RESPONSE

TO THE MICA SEPA CHECKLIST ATTACHMENT Q

AS FILED WITH THE CITY OF MERCER ISLAND

ON JANUARY 18, 2017

# EXHIBIT A

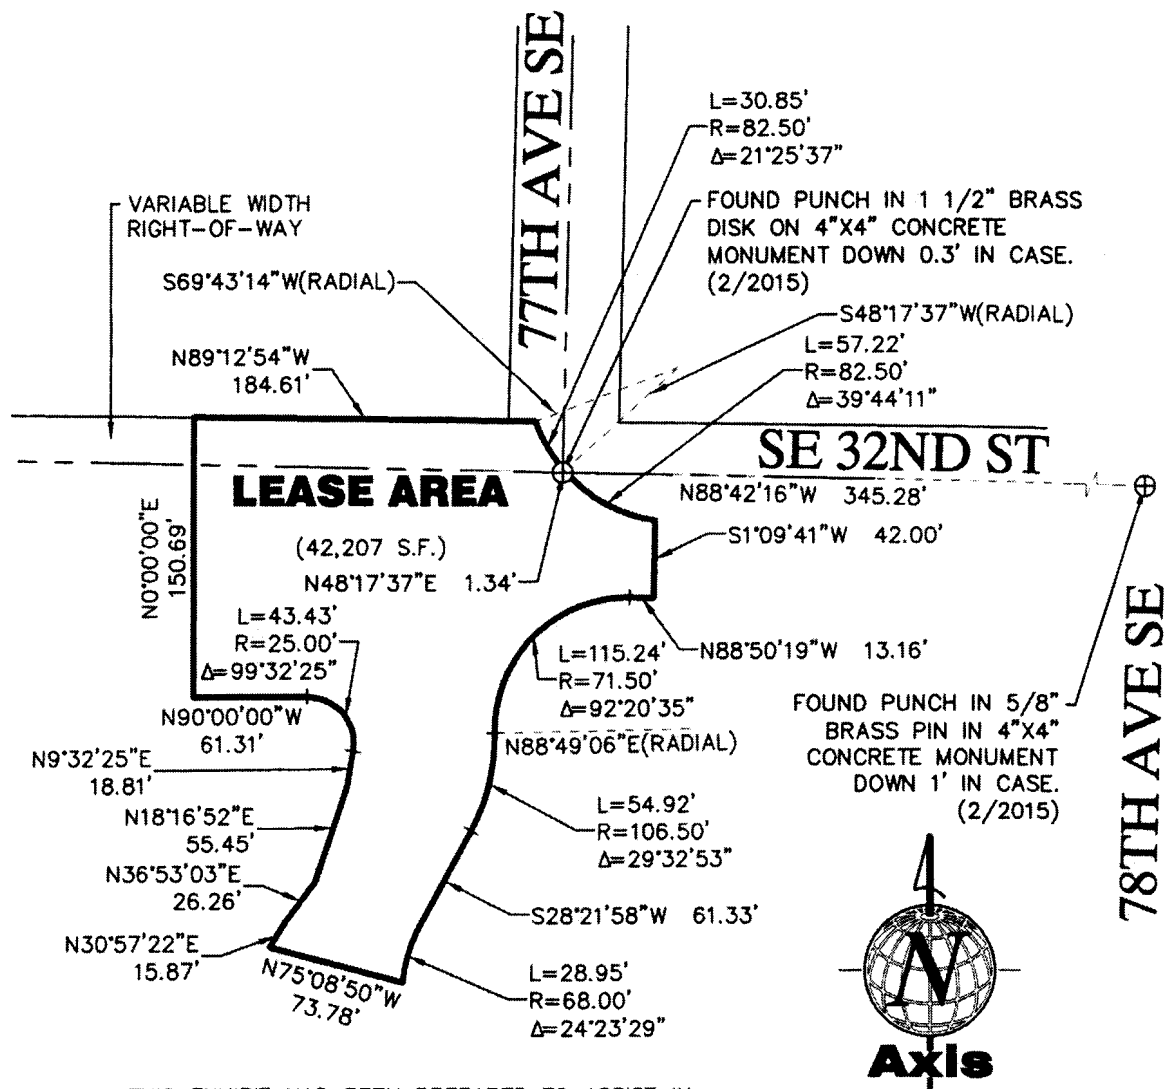
The proposed lease boundary (as shown in Attachment A – Survey/Proposed Lease Boundary) and proposed building footprint (as shown in Attachment B – Aerial/Proposed Building Footprint) infringes upon the right-of-way of S.E. 32nd Street west of 77th Avenue S.E. That right-of-way may in fact prove to be needed for future extension of S.E. 32nd Street west to 76th Avenue S,E, to mitigate the traffic problems being created by the I-90 mobility issues, especially the loss of SOV access to I-90 via Island Crest Way. The City has wisely retained this right-of-way to allow for the possibility that it will be needed for future road construction. Vacating this right-of-way would deny the City the use of this land in perpetuity.

In order to fully accept the SEPA application as complete, the City needs to ask MICA to address the issue of street vacation (see MICC.19.09.070) and ask the City Council, as the property owner, to so petition for same so that the proper procedure is followed and due process is allowed to take place to insure that the public interest is best served by the vacation.

SHEET NAME
SITE AND PAVING PLAN

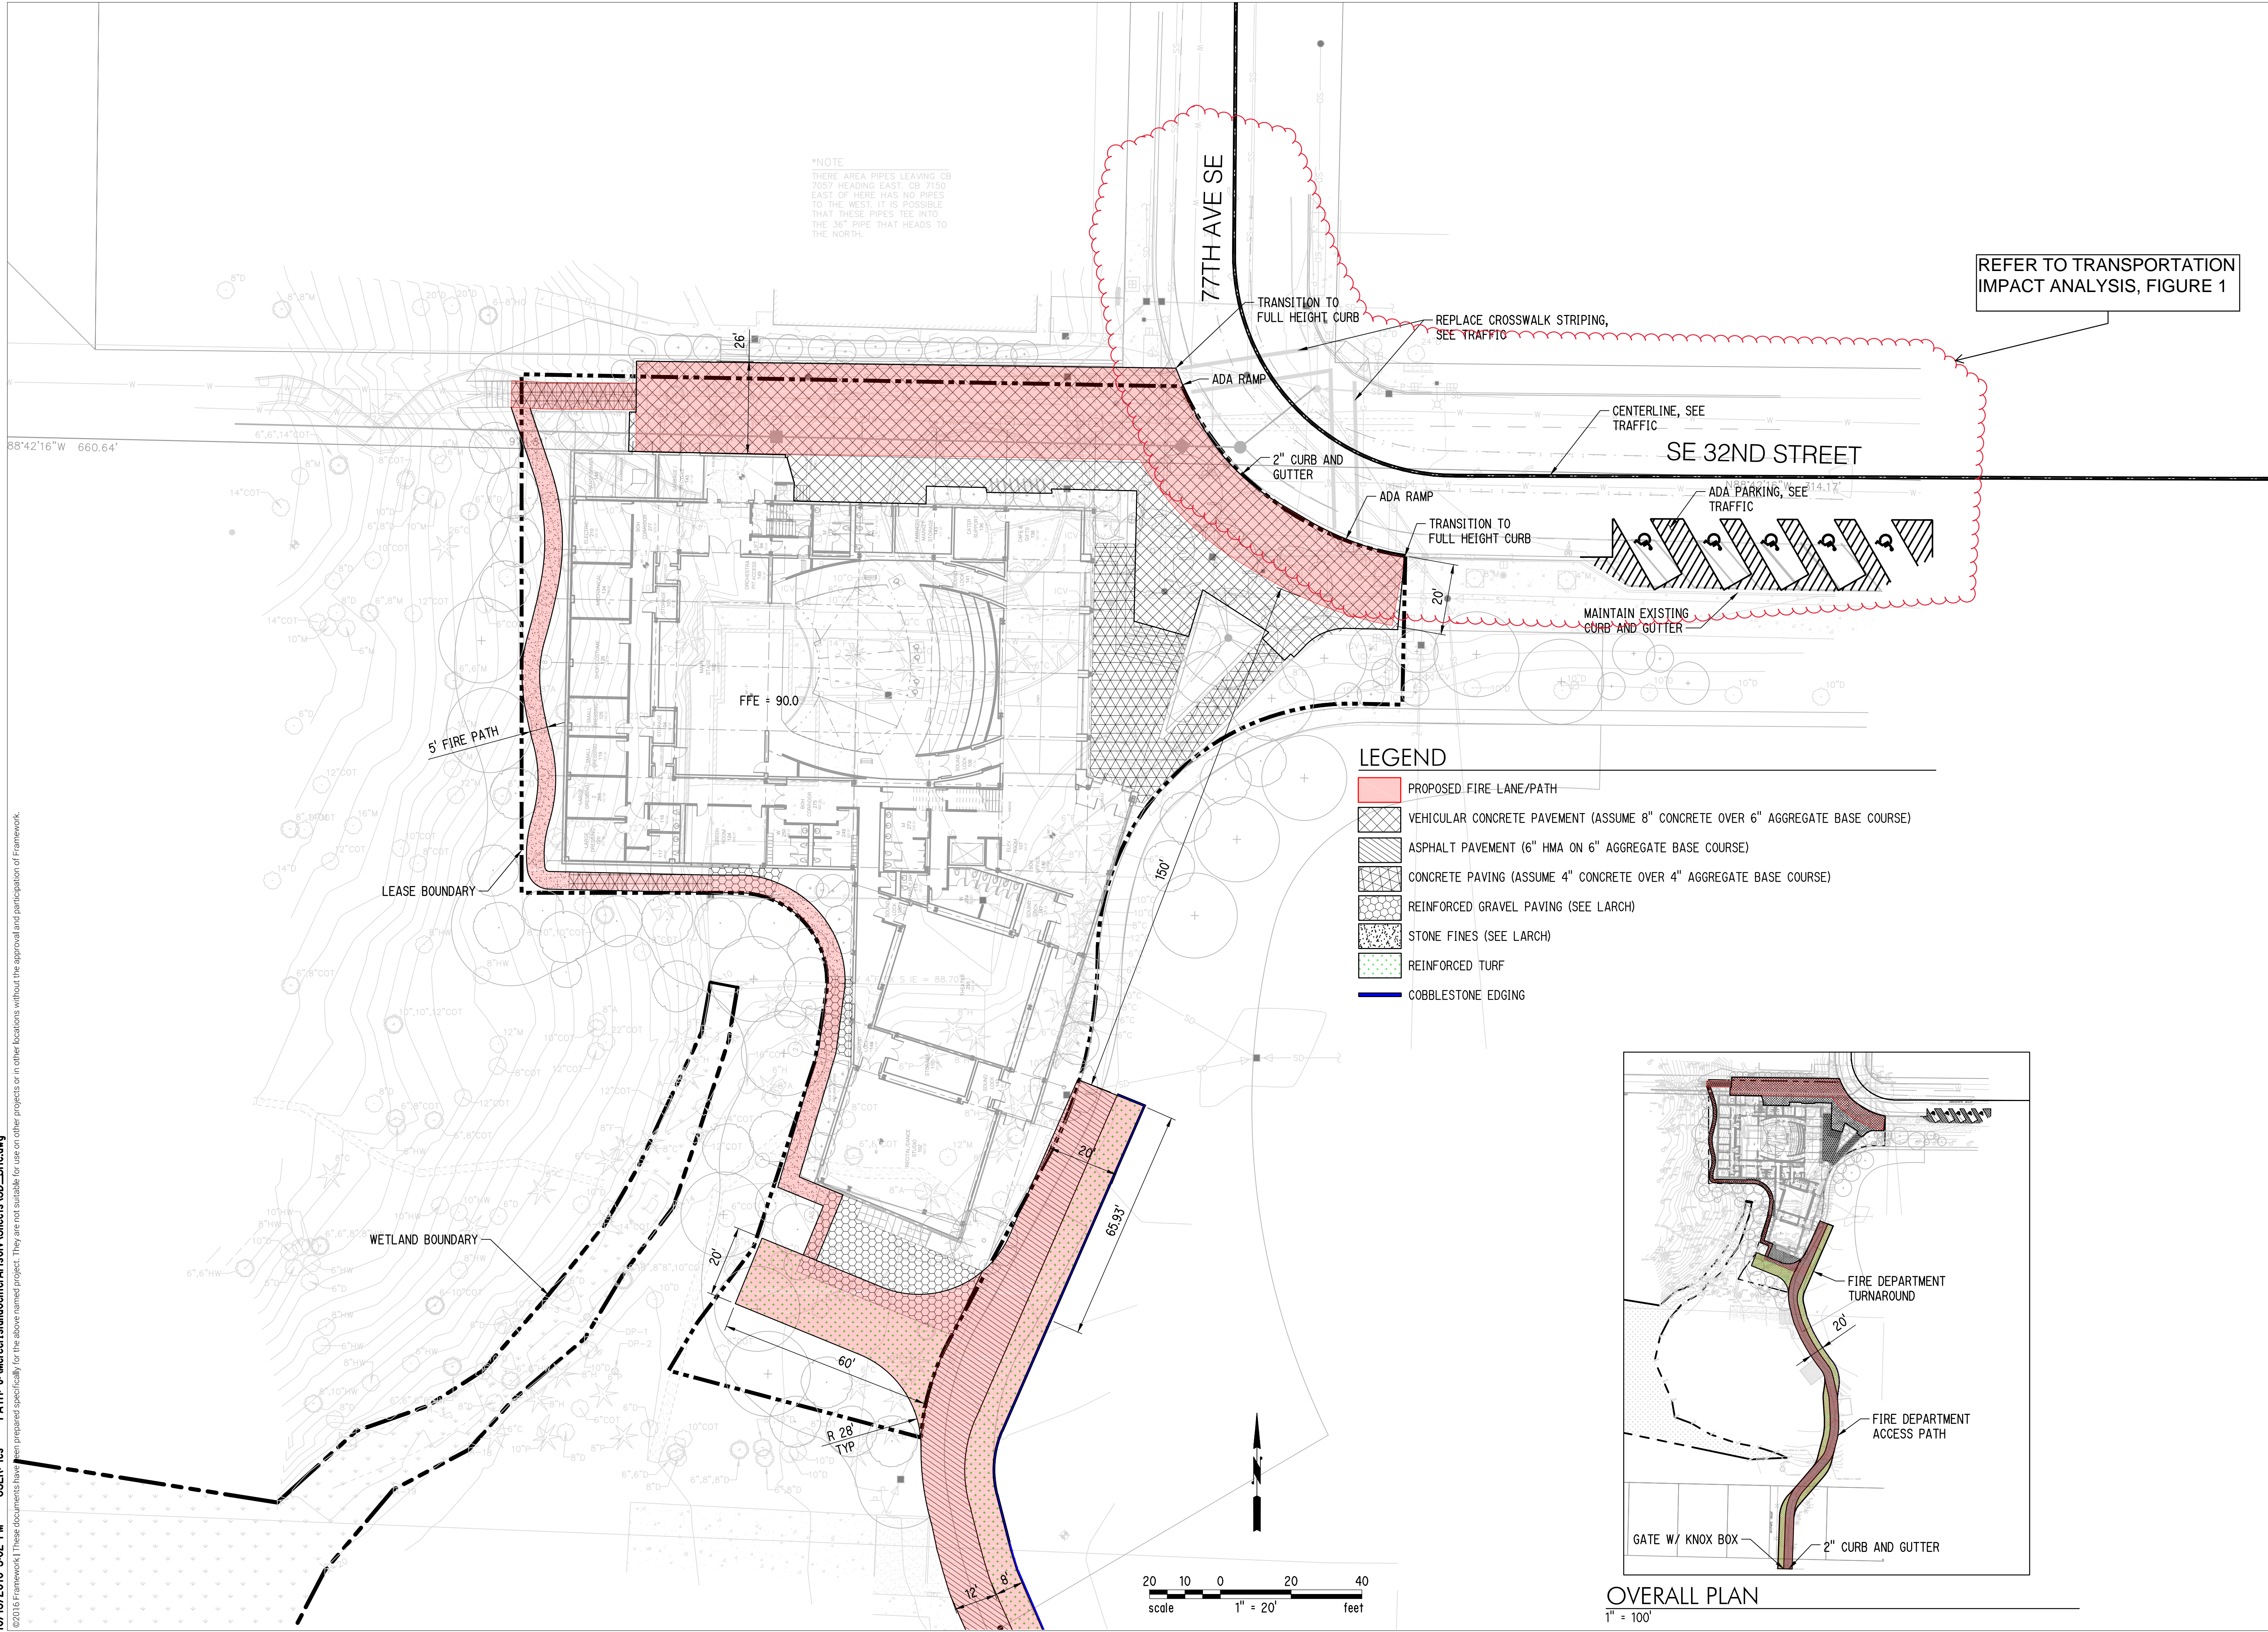
MICA does not clearly state that the west side of the perimeter path will actually be a 20’ wide paved fire lane. Also, it states that the First Hill trail will be restored, but fails to note that the trail will now be sandwiched between large buildings – clearly a diminution in one’s experience.

The City's public safety units including police and fire need to opine on the necessity and safety of the how the building and site are being laid out and designed. For example, one immediate reaction is why the fire lane is coming in off of S.E. 34th Street as opposed to the much closer S.E. 32nd Street. Any logical review would suggest that one would want the fire department access as close as possible. Moreover, designing the fire lane to intersect with S.E. 34th Street requires much more impervious surface to be located in the park (which goes against the basic aesthetics of a park).

In order to fully accept the SEPA application as complete, the City needs to ask MICA for their specific rationale for locating the fire lane as depicted, and for the ways they intend to address safety and other related issues. Then the City needs to ask MICA to ask the police and fire chiefs if they accept the MICA emergency access plan as the very safest and best way to reach the facility in case of medical or fire emergencies, and if so, then MICA needs to ask that the Police and Fire chiefs confirm in writing their acceptance of the MICA emergency plans as the very best and safest plans to prevent children's injuries and loss of life in the event of unexpected emergencies.
